From: Martyn White <Martyn.White@arun.gov.uk> **On Behalf Of** Conservation Officer
Sent: 02 October 2026 16:15
To: Planning.Responses <Planning.Responses@arun.gov.uk>
Cc: Kathryn Welch <Kathryn.Welch@arun.gov.uk>
Subject: LU/174/26/PL

LU/174/26/PL

Address: Flint Acre Toddington Lane Littlehampton BN17 7PN

Proposal: Erection of a detached dwelling with open carport.

Drawing Title
Existing Site Layout Plan, Proposed Front Elevation indicating Site Levels.

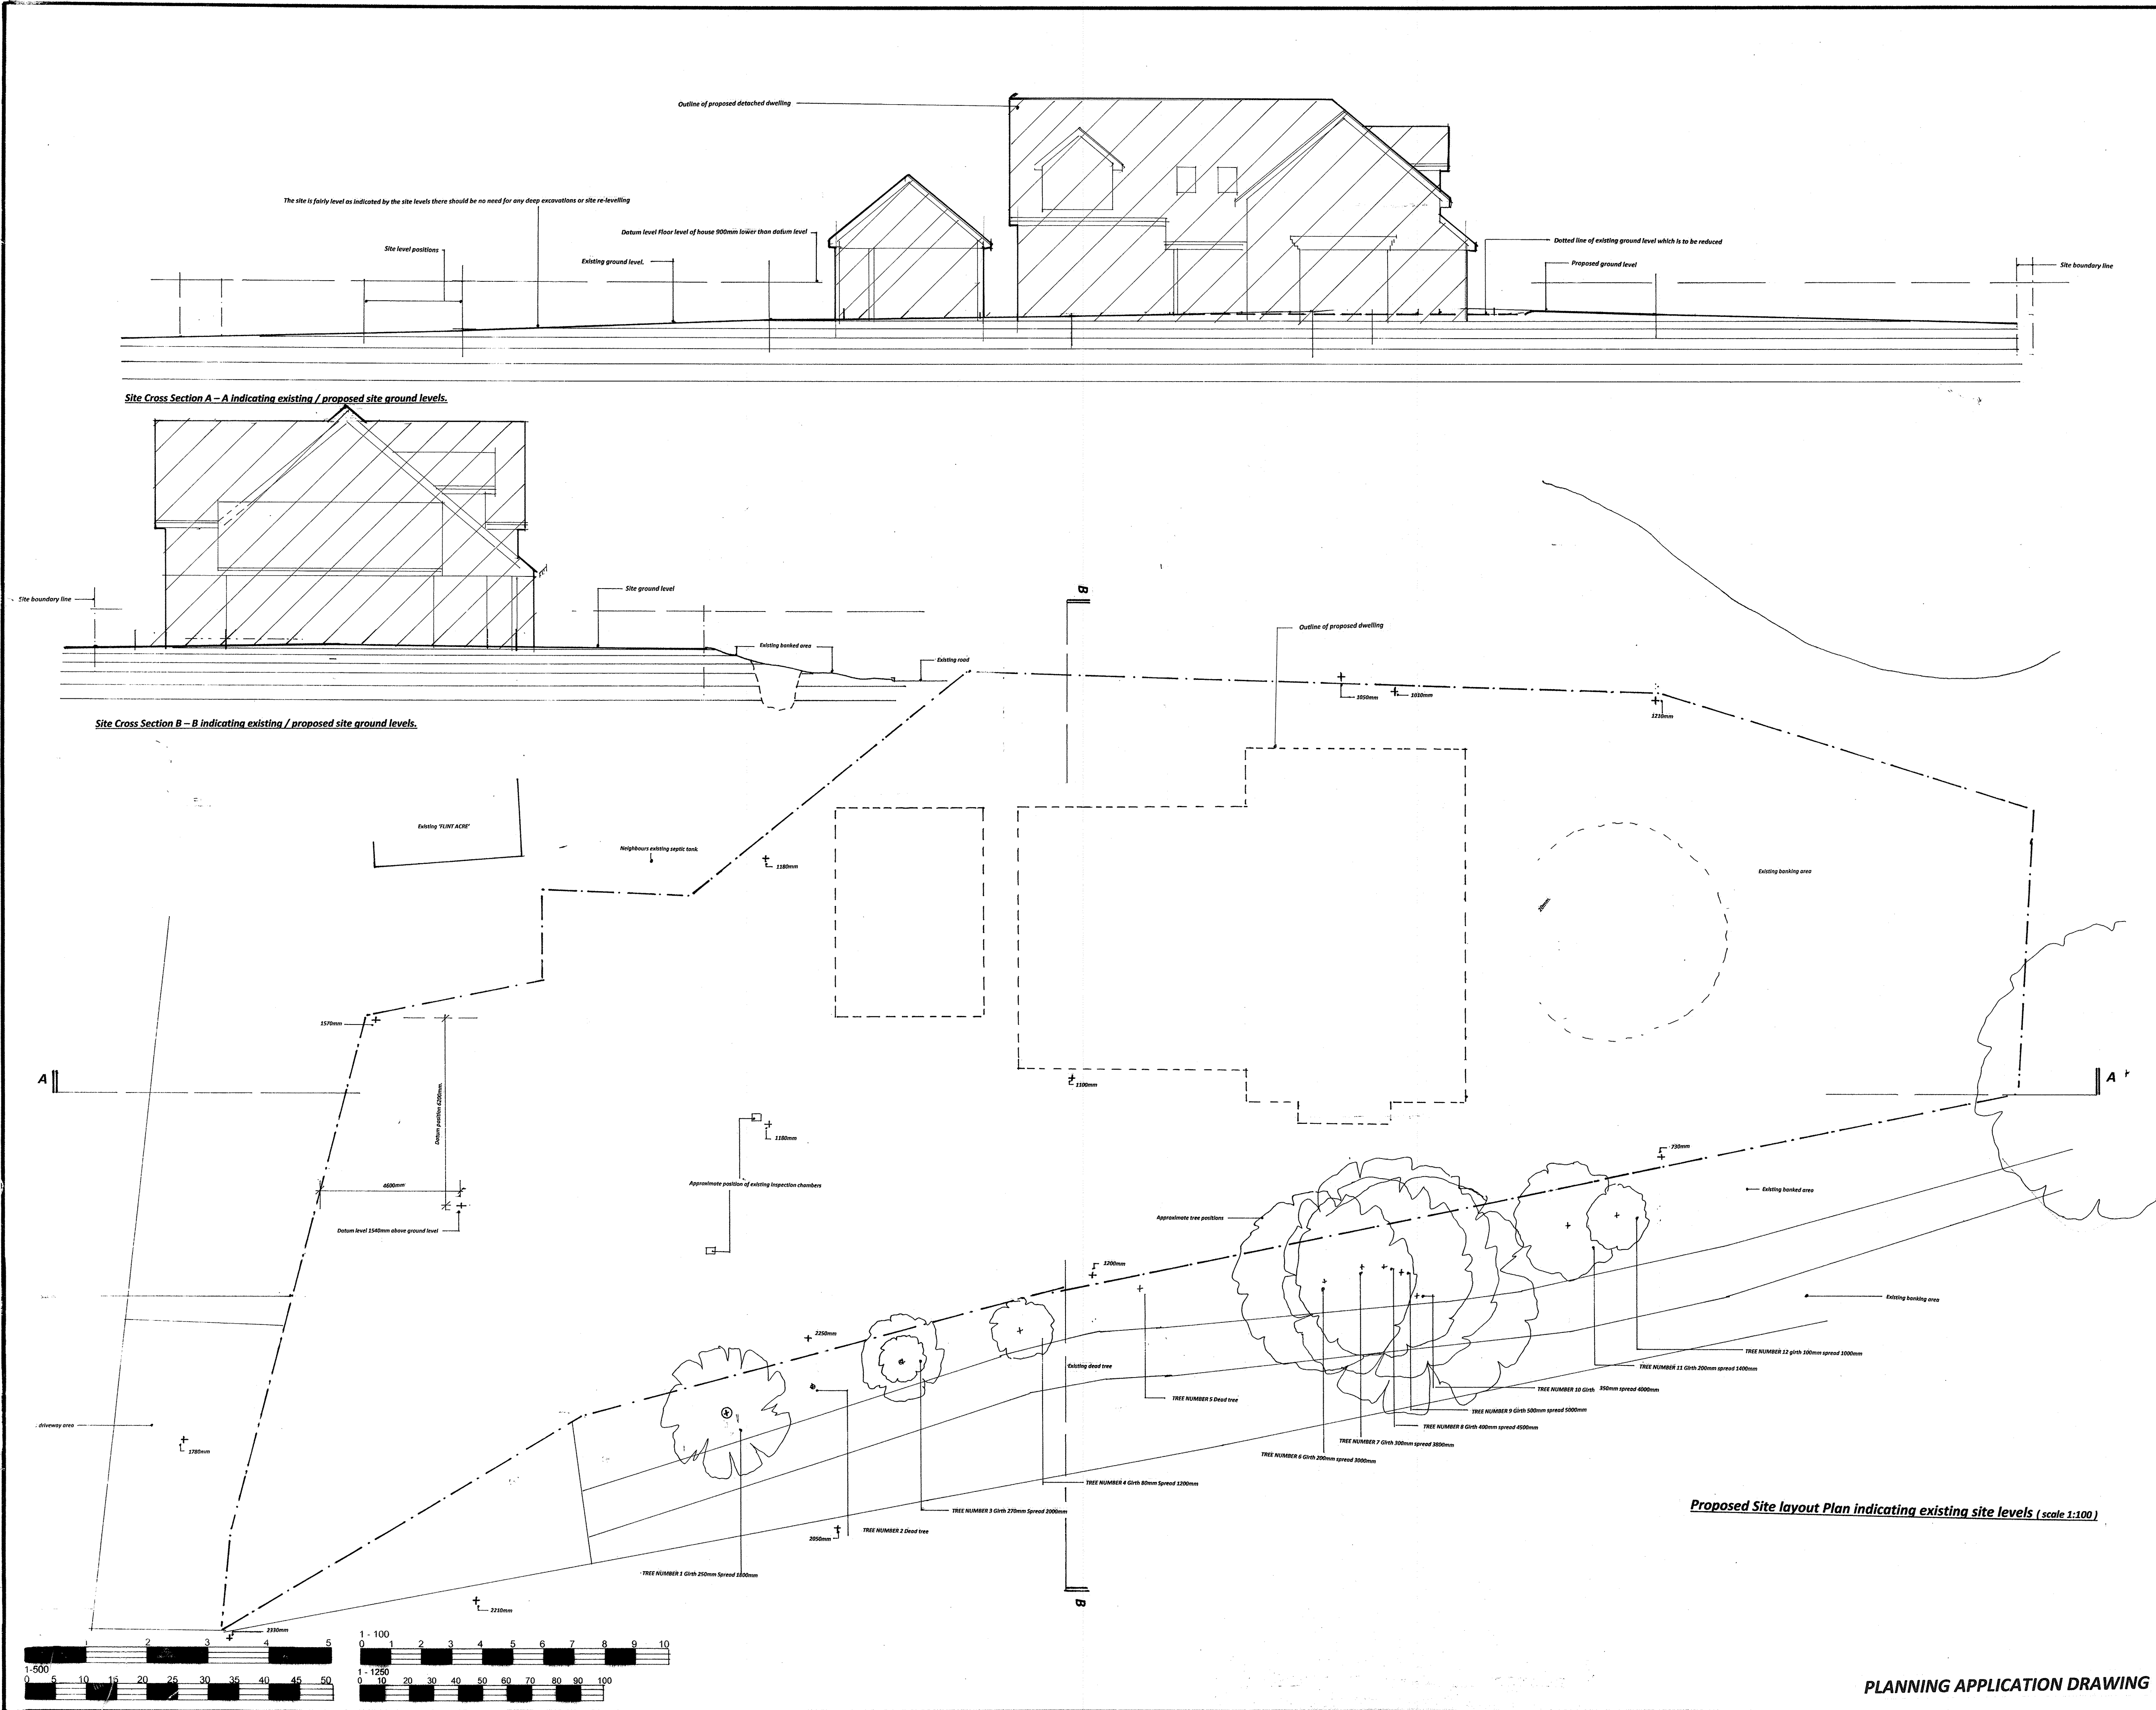
I note in the current Planning Statement that whilst several trees are considered to be dead, they will be replaced, which is positive as this will ensure that the site remains screened from the lane. I would request that these replacement trees are more mature when planted so as to have greater impact at the start of the lifetime of the development. I will leave comments on the suitability or not of the trees proposed to our colleagues in the Parks/landscaping department.

It would also help if there was some lower vegetation or shrubs to help maintain a 'green' street frontage, even in the winter months when the trees have shed their leaves – during a recent site visit it was clear that when the trees had no leaves that the majority of the site was visible.

The presence of the existing and proposed replacement vegetation to the front of the site would mean that the proposed dwelling should not be clearly seen in the context of the neighbouring listed buildings, when looking eastwards (from the lane to the front of the site) or westwards from the lane to the front of the heritage assets.
